# CITY OF PORTLAND, MAINE

July 20<sup>th</sup>, 2015

Project Name: Jewish Community Center and Preschool/Daycare  
Conditional Use and Level III Site Plan

Project #: #2015-058 (Conditional Use and Site Plan)

SITE PLAN

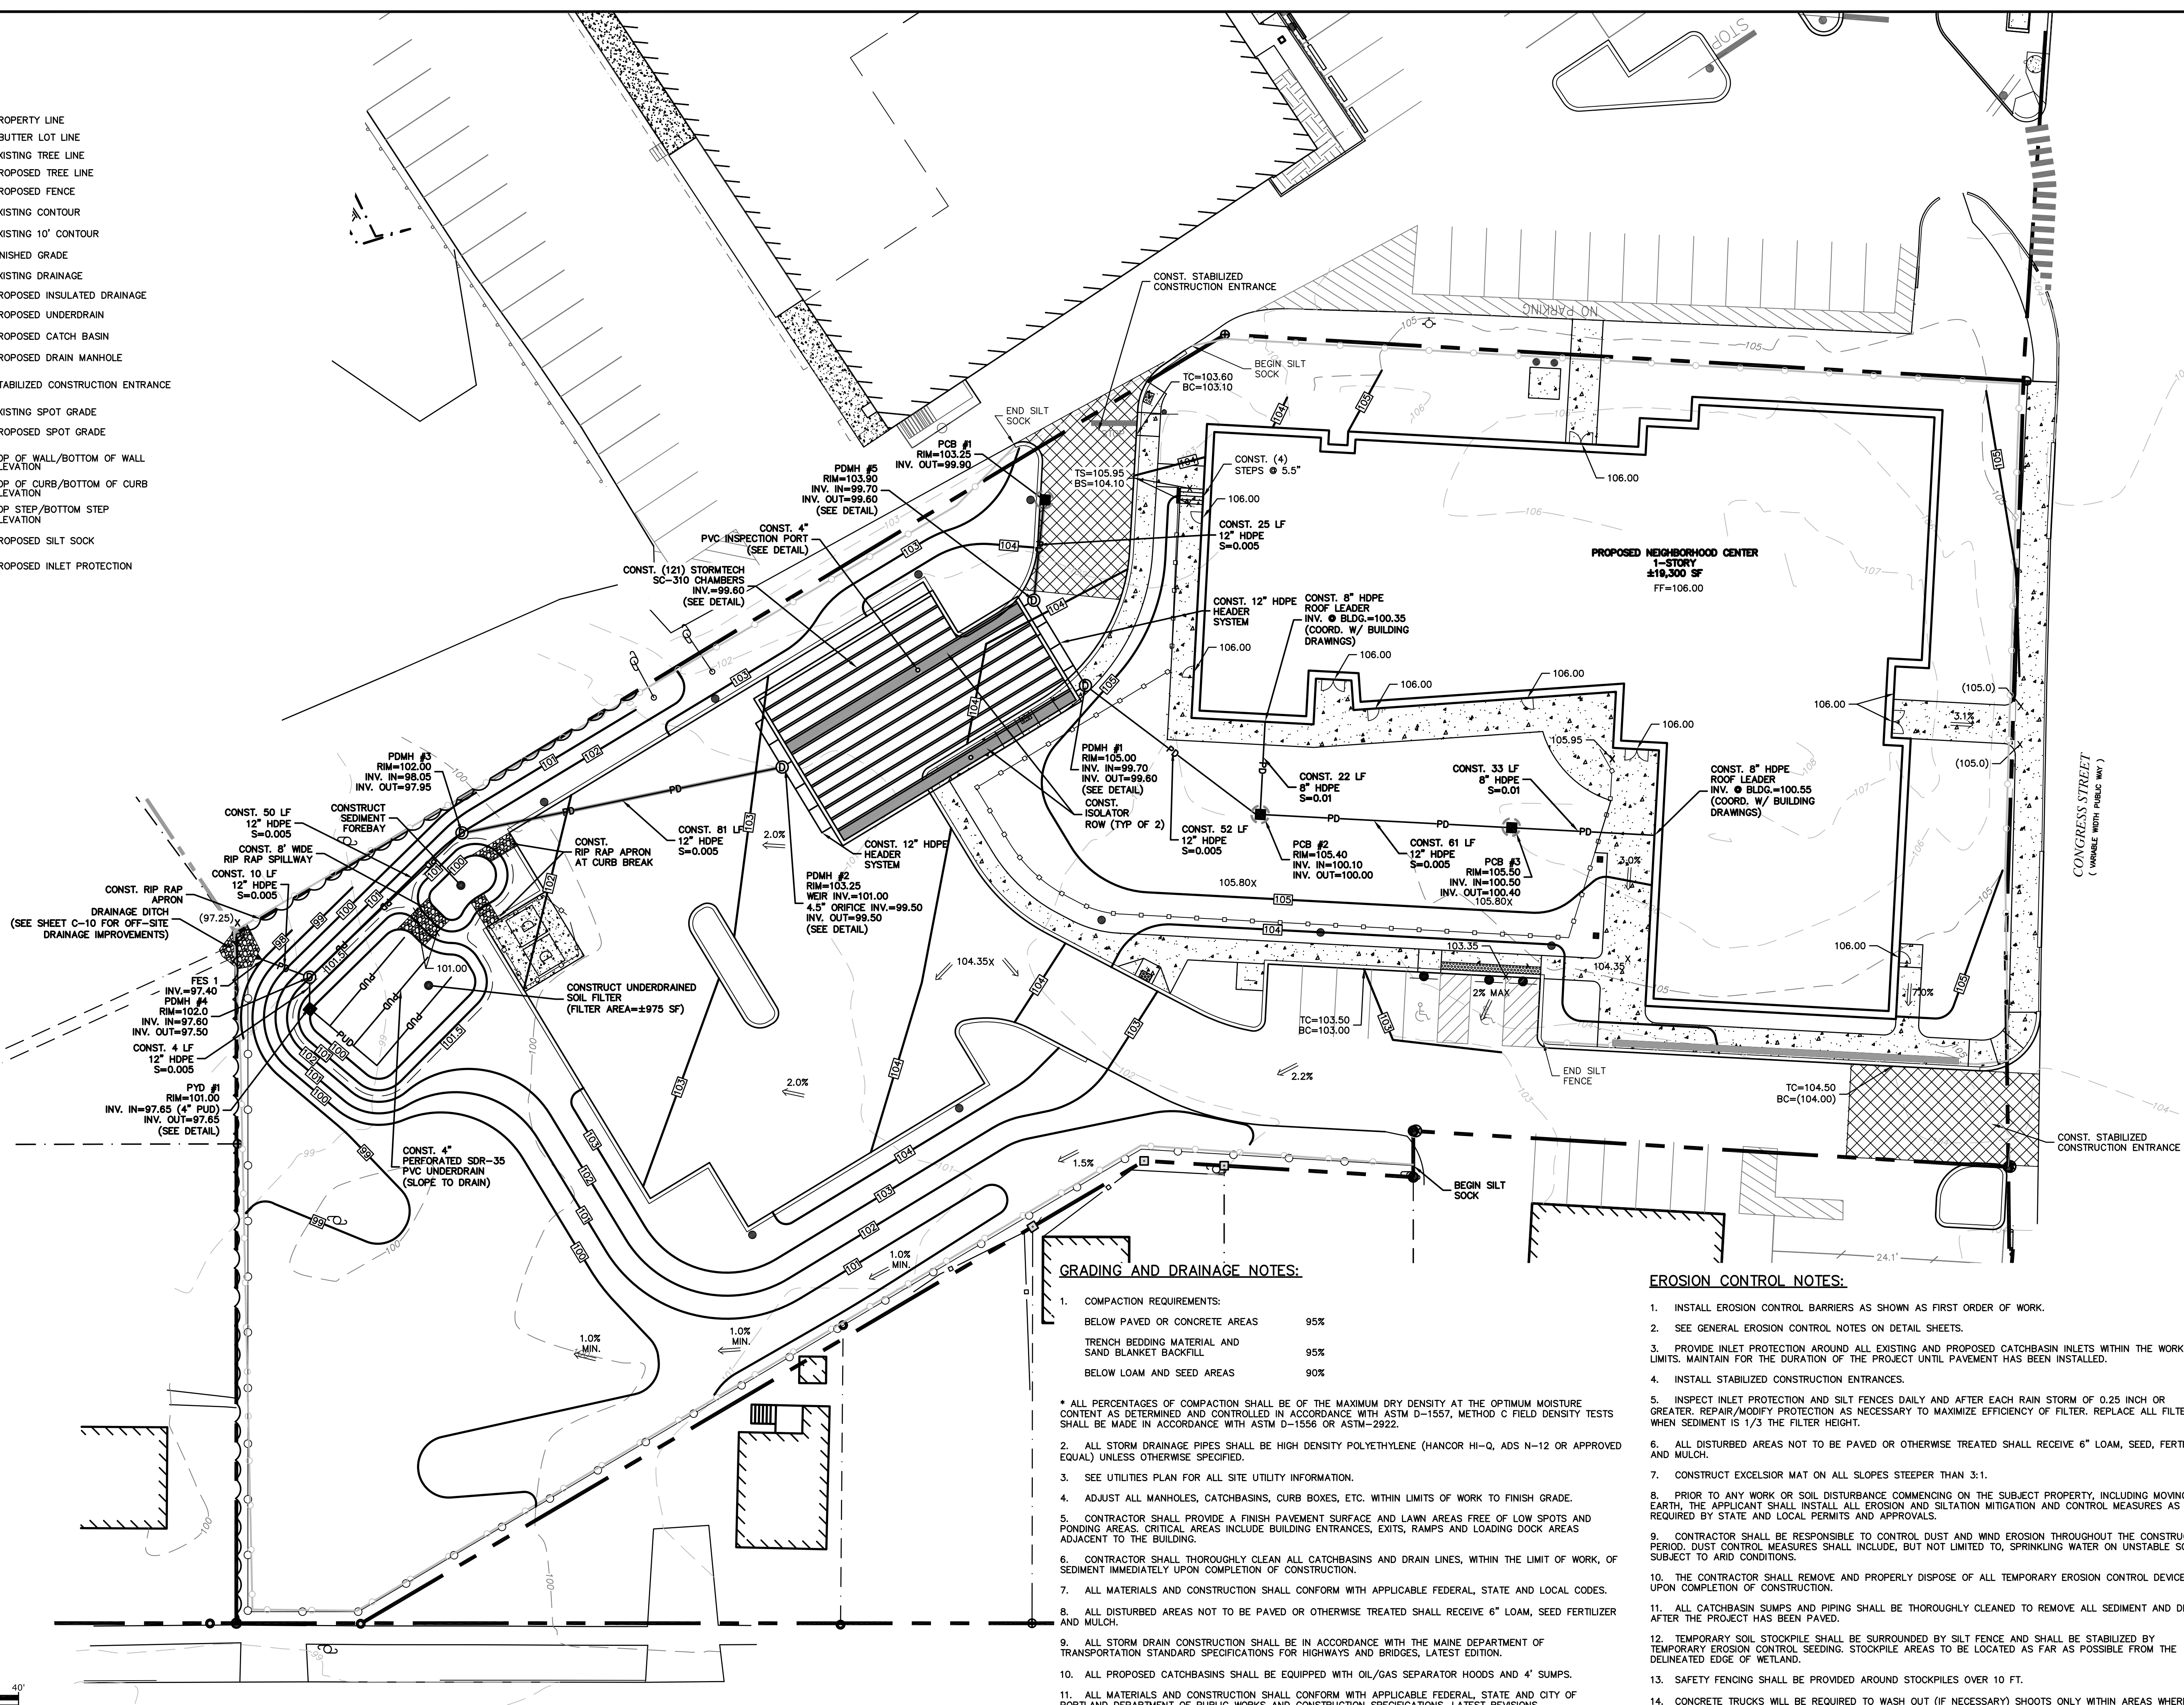
The Planning Board voted 6-0 (Morrissette absent) to waive Technical Design Standard Section 1.7.1.3 to allow the proposed driveway to be 22.7 feet wide for one section near Congress Street as shown on the Site Plan in Plan P6;

- iii. That the applicant revise the curb ramp layout at Congress Street in accordance with the comments of Tom Errico dated June 26, 2015, with revised plans to be reviewed and approved by the Planning

- I would suggest a tip-down curb entering the driveway on Congress Street, as currently provided.

**Status: The curb ramp layout should be revised so that the ramp flare does not impact accessibility along the sidewalk route. Having a tip-down design will help to address this issue.**
